**KIRKLEES METROPOLITAN COUNCIL
INVESTMENT & REGENERATION SERVICE**

Reference No:	2023/62/92198/E
Site Address:	47, Oddfellows Street, Scholes, Cleckheaton, BD19 6NX
Description:	Erection of first floor side extension
Recommending Officer:	Katie Wilson

HOUSEHOLDER DELEGATED REPORT

Application Number	2023/92198
Location	47, Oddfellows Street, Scholes, Cleckheaton, BD19 6NX
Proposal	Erection of first floor side extension
Publicity end date	19 th October 2023
Number of representations received	None
Kirklees Local Plan Allocation/Designation	Unallocated
Extension to Time (EoT)	Yes EoT Date: 6 th February 2024
Recommendation	Conditional Full Permission

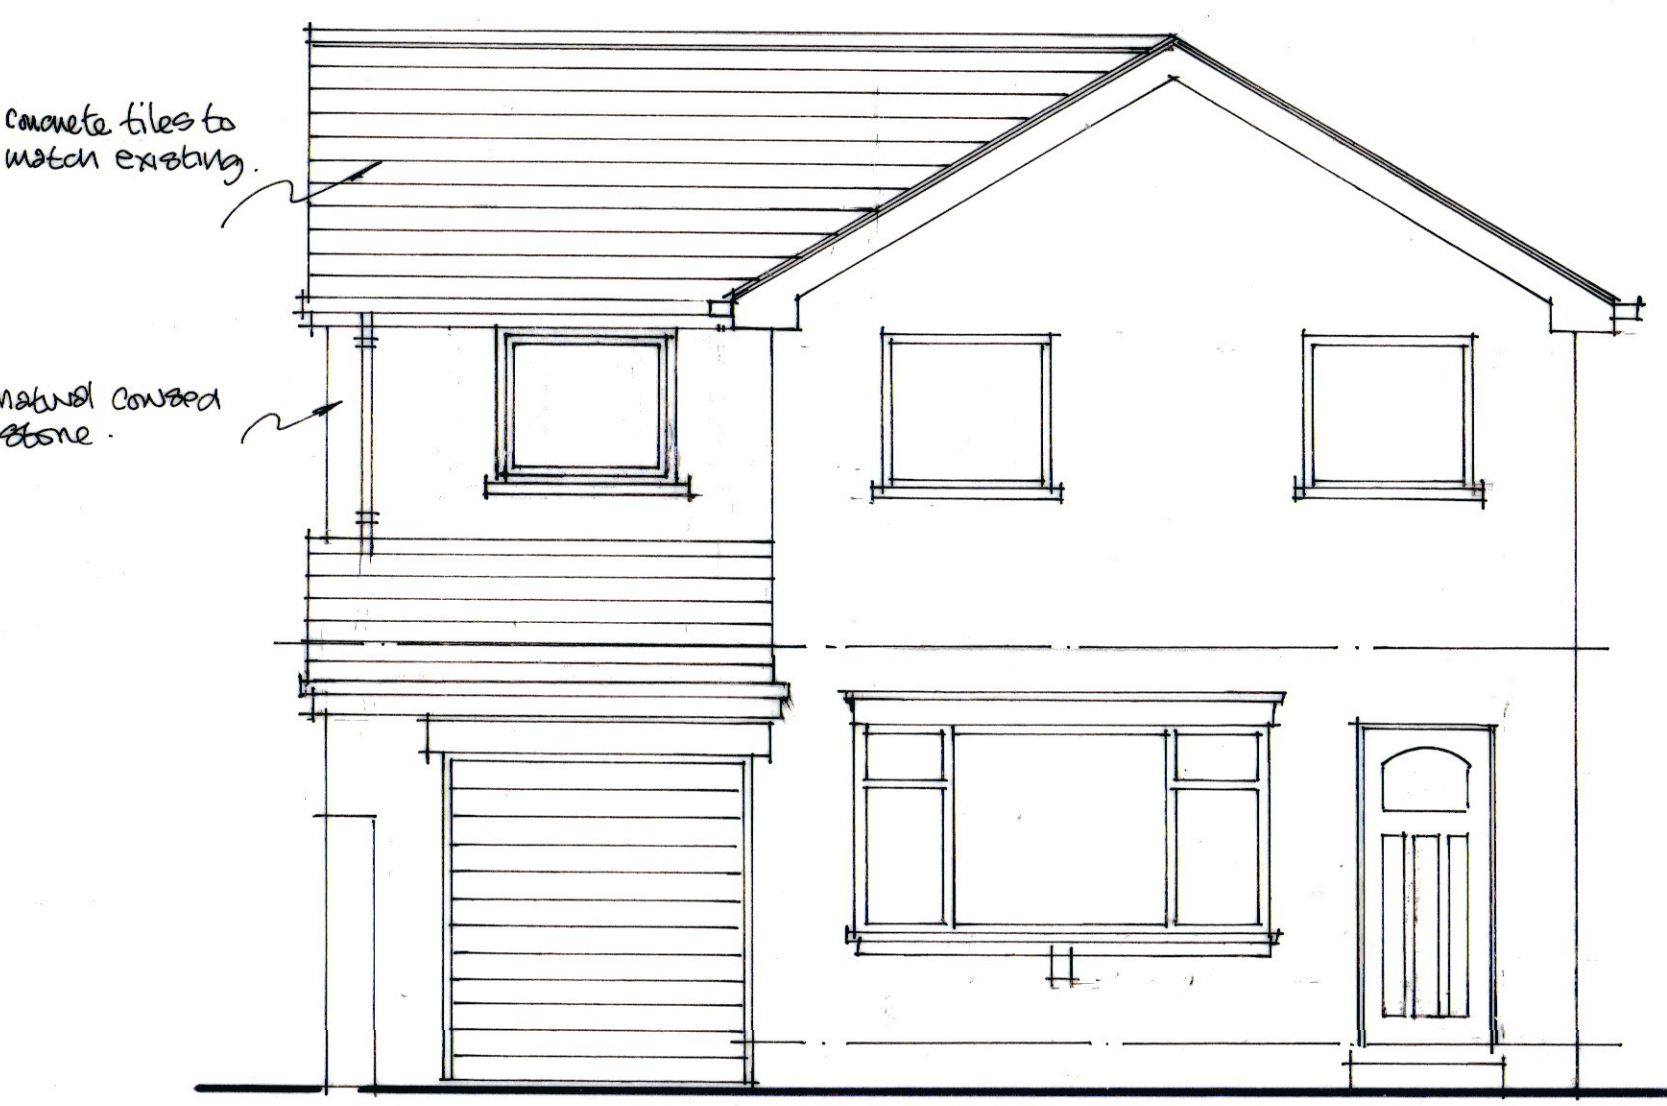
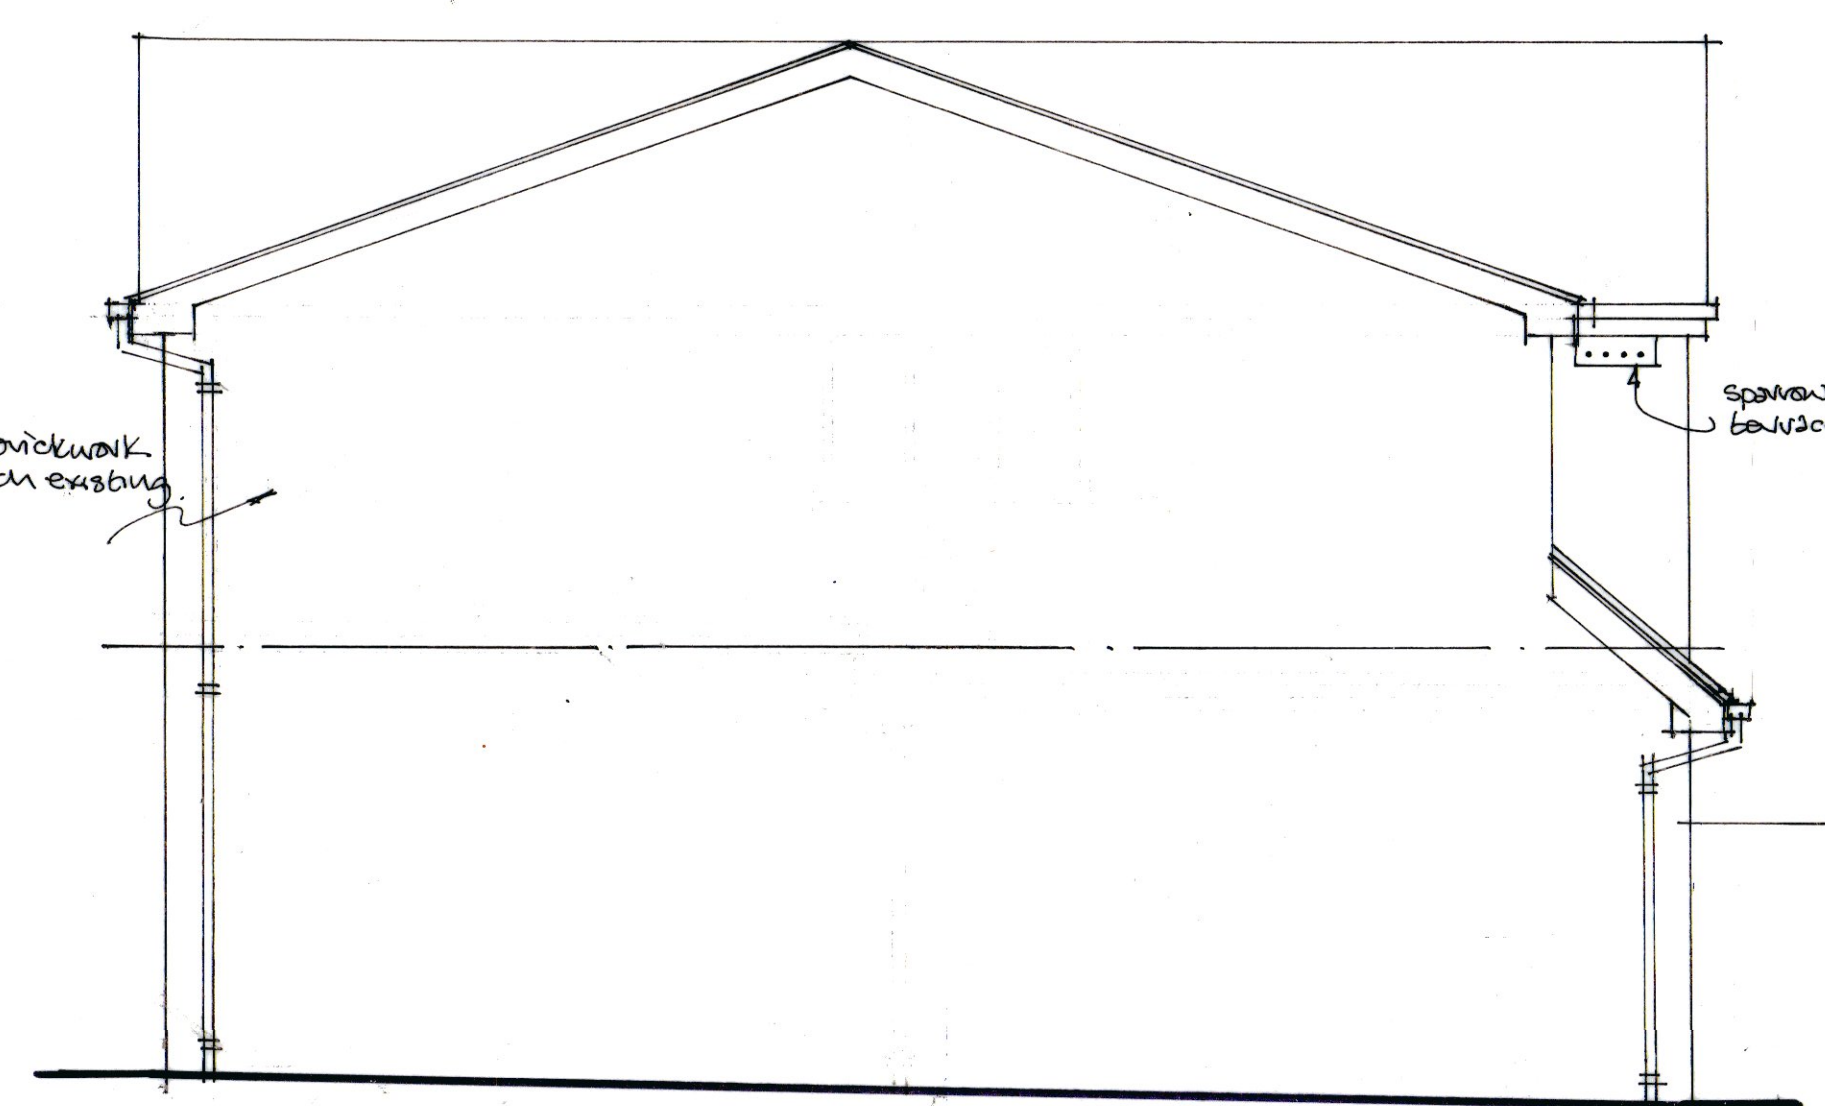
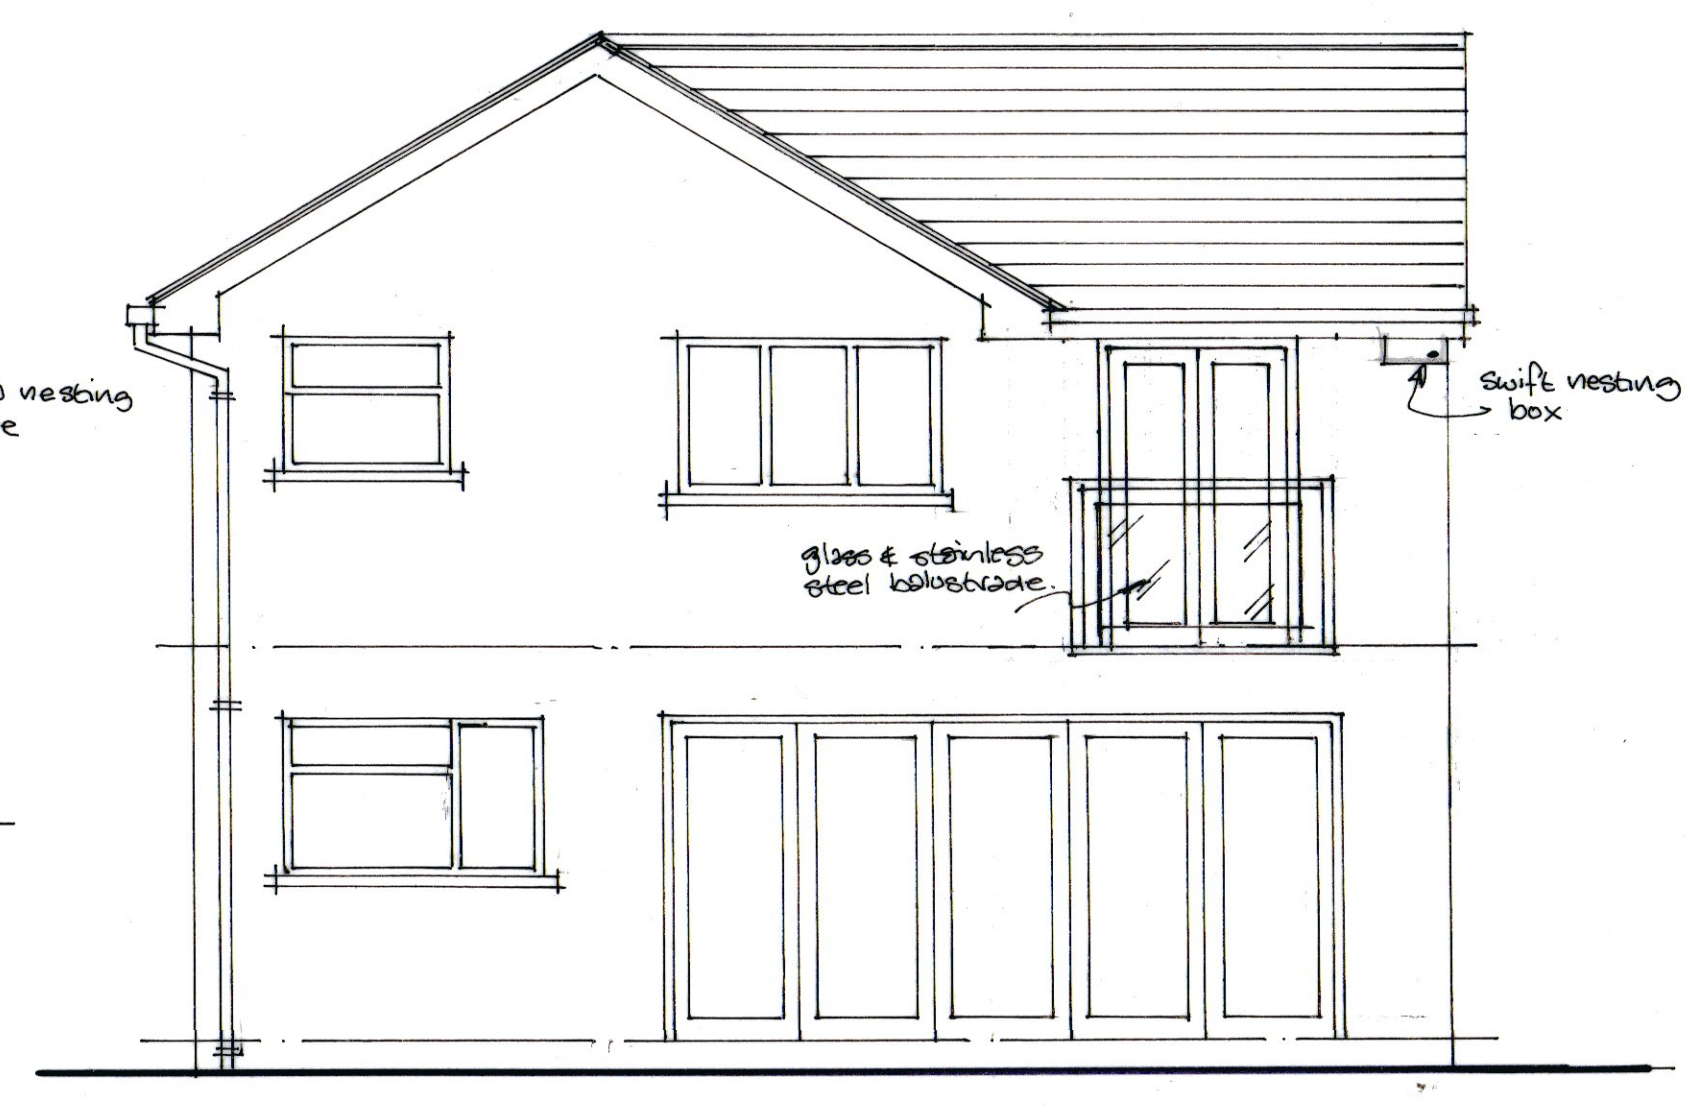
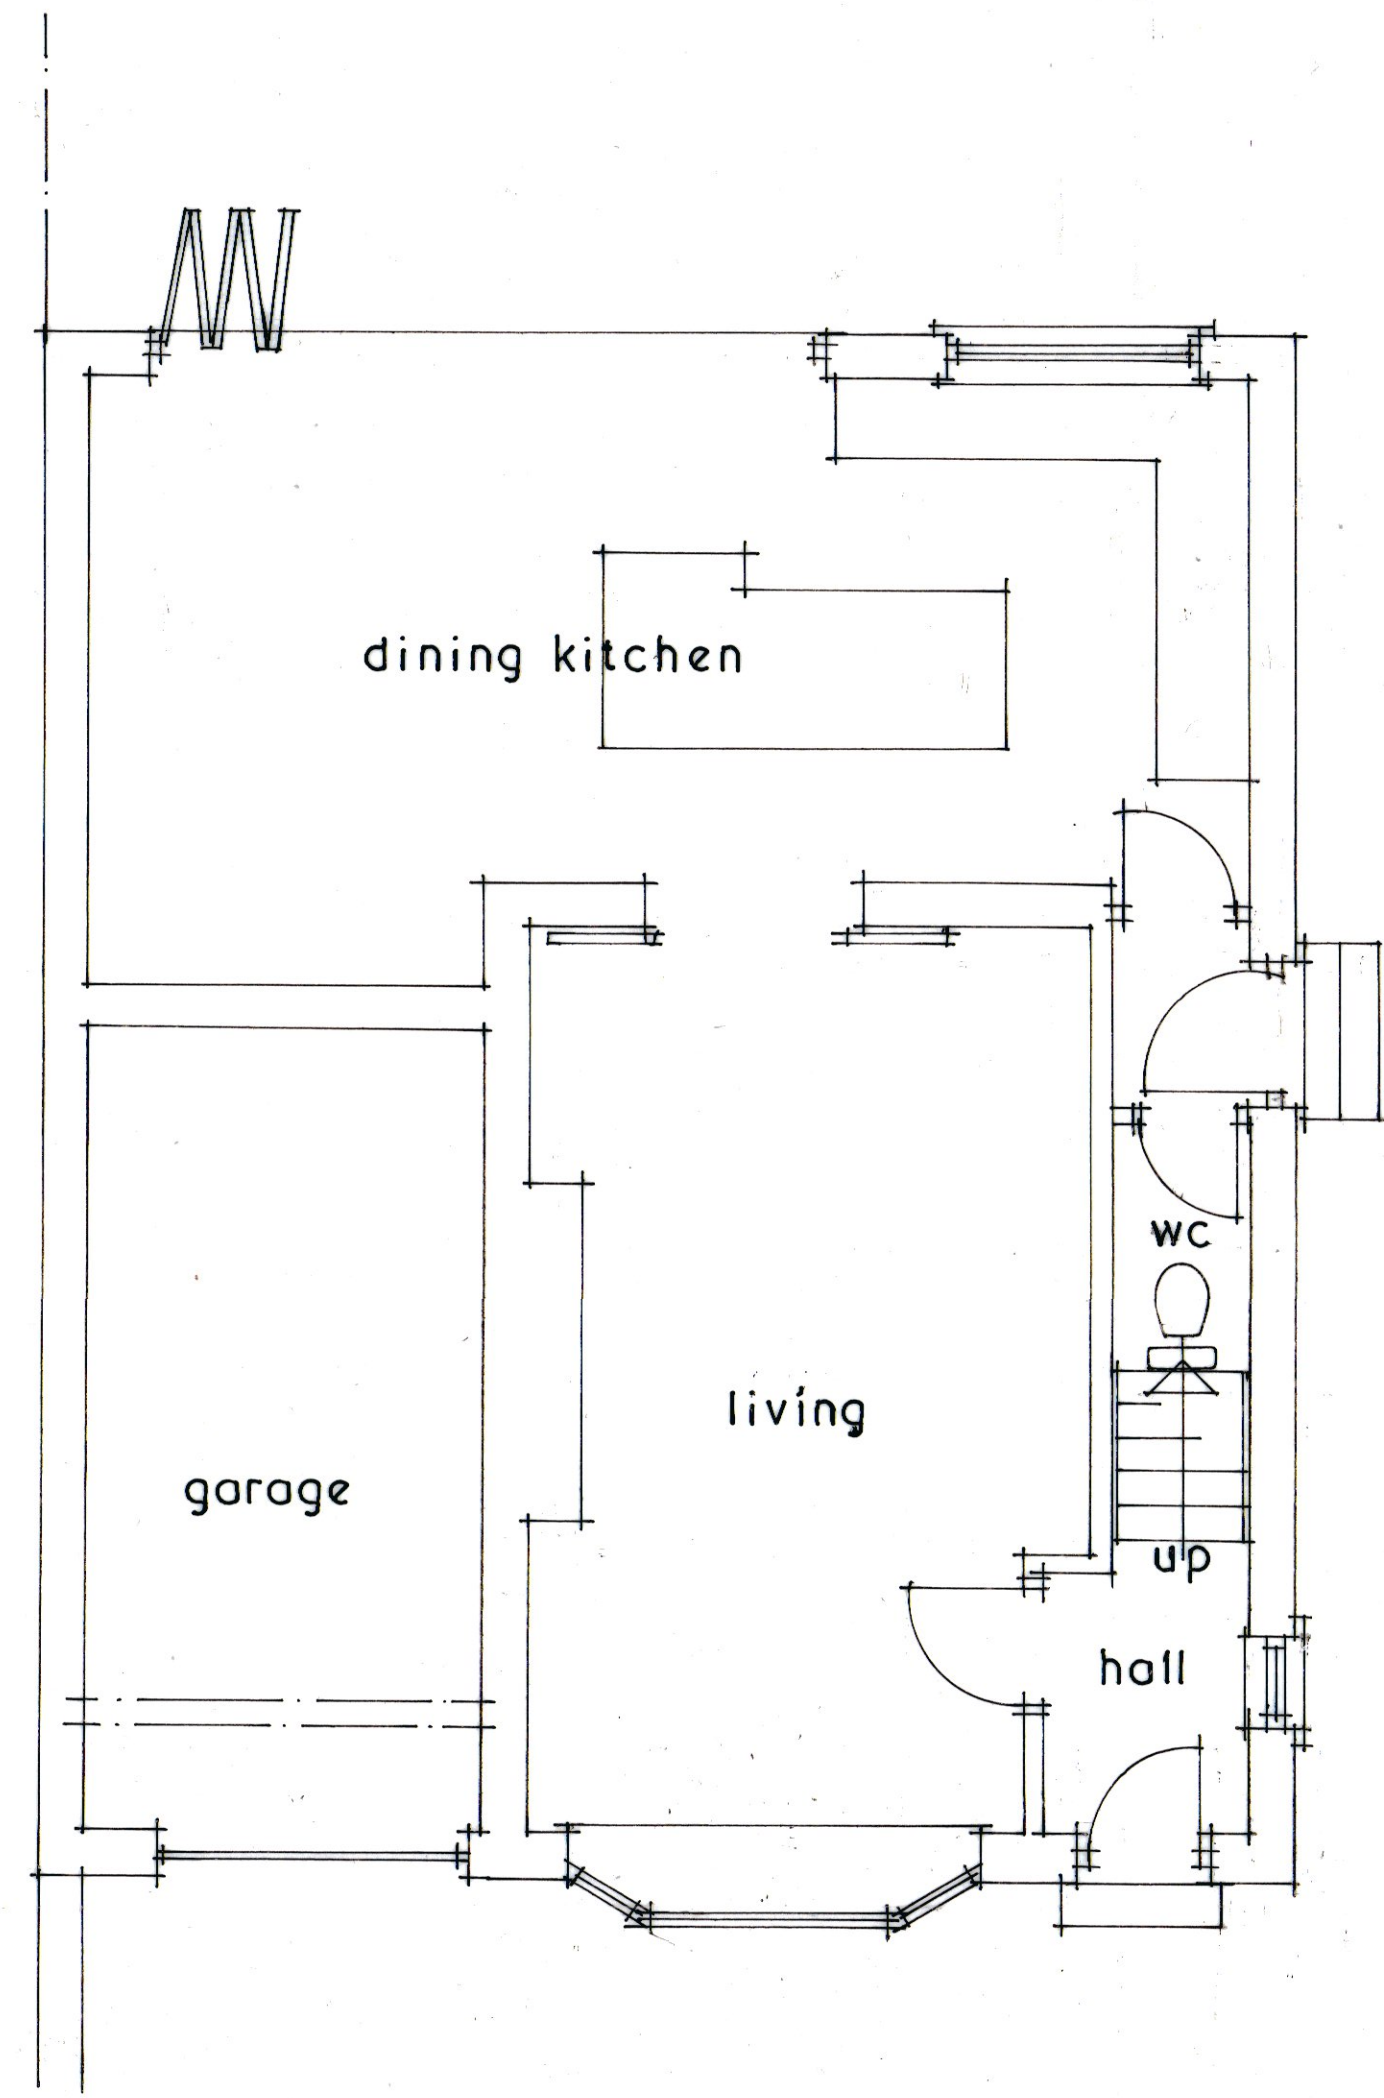
properties in the same row. Most of the others have first floor side extensions of various designs. These mitigating circumstances are sufficient to provide justification for not complying with this criteria.
Maintain a 1 metre gap to the side boundary to ensure the building is not too close to a neighbouring property		No. For the same reasons as above, it is considered that there are sufficient mitigating factors to justify non compliance with this criteria.
Be set back at least 500mm from the front wall of the house.	Yes. The first floor element would be set back approximately 1.0m from the front elevation.

Roof style	• KDP 1 and 2 of the SPD • Policy LP24 Design (a), (c) and (d) of the KLP • Chapter 12 of the NPPF	It would have a dual pitched roof which is in keeping with that on the original part of the house. The angle of pitch would be lower, but nevertheless this is considered not to detract from the appearance of the host dwellinghouse, and is acceptable in terms of KDP 1 and 2 of the SPD and policy LP24 of the KLP.	✓
Window proportions	• KDP 1 and 2 of the SPD • Policy LP24 Design (a), (c) and (d) of the KLP • Chapter 12 of the NPPF	The proposed window on the front elevation would match those on the host dwellinghouse. On the rear elevation would be set of patio doors and Juliet balcony. This would replicate to some extent the bi-folding doors at ground floor level in the rear elevation. Whilst it is unknown if the existing bi-folding doors are original features, it is nevertheless thought that the Juliet balcony feature would be inkeeping with the domestic appearance of the building.	✓

Relevant key design principle (KDP) of the SPD, Policy in the Kirklees Local Plan and the NPPF	Further comments	✓ / X / N/A
Impact on privacy of neighbours.	• KDP 3 & 4 of the SPD • Policy LP24 Design (d) (iv) • Chapter 12 of the NPPF	In this instance the proposed extension would be very close to the boundary with 45, Oddfellows Street and have no openings in its side elevation. The facing side elevation at 45, Oddfellows Street contains one door and small window at ground floor with one other small window at first floor level to a landing. There would be a separation distance of around 3.0m. The new first floor includes habitable accommodation that would have a view to the rear. As the existing first floor includes windows it is not considered that the proposed will result in a loss of privacy over and above the existing relationship. Provided permitted development rights are removed for new openings in the side of the proposed first floor	✓

extension, the proposal is considered to comply with KDP3 & 4 of the SPD and policy LP24 of the KLP.	
Impact on light and outlook of neighbours	• KDP 4, 5, 6 of the SPD • Policy LP24 Design (b) • Chapter 12 of the NPPF	The additional massing of the proposed first floor side extension would have potential to cast additional shade particularly in the first half of the day. However, this would be mainly over the side eastern side of the house and external walkway. Much of the front and rear outdoor amenity space would be unaffected. Whilst the footprint of the houses in this row are slightly staggered, it is considered that this would not have a significant impact upon the outlook from 45, Oddfellows Street. The main windows to this neighbouring property look directly out onto the front and rear gardens and in officer's opinion would be largely unaffected by the proposed extension. As such it is considered to be compliant with KDP 4, 5, & 6 of the SPD. It would accord with policy LP24 of the KLP.	✓

4. Notwithstanding the provisions of the Town and Country Planning (General Permitted Development) (England) Order 2015 (as amended), or any subsequent legislation revoking or superseding that Order, no windows, doors or other openings, other than those shown on the approved plans, shall, at any time, be formed within the west facing side elevation of the approved first floor side extension.
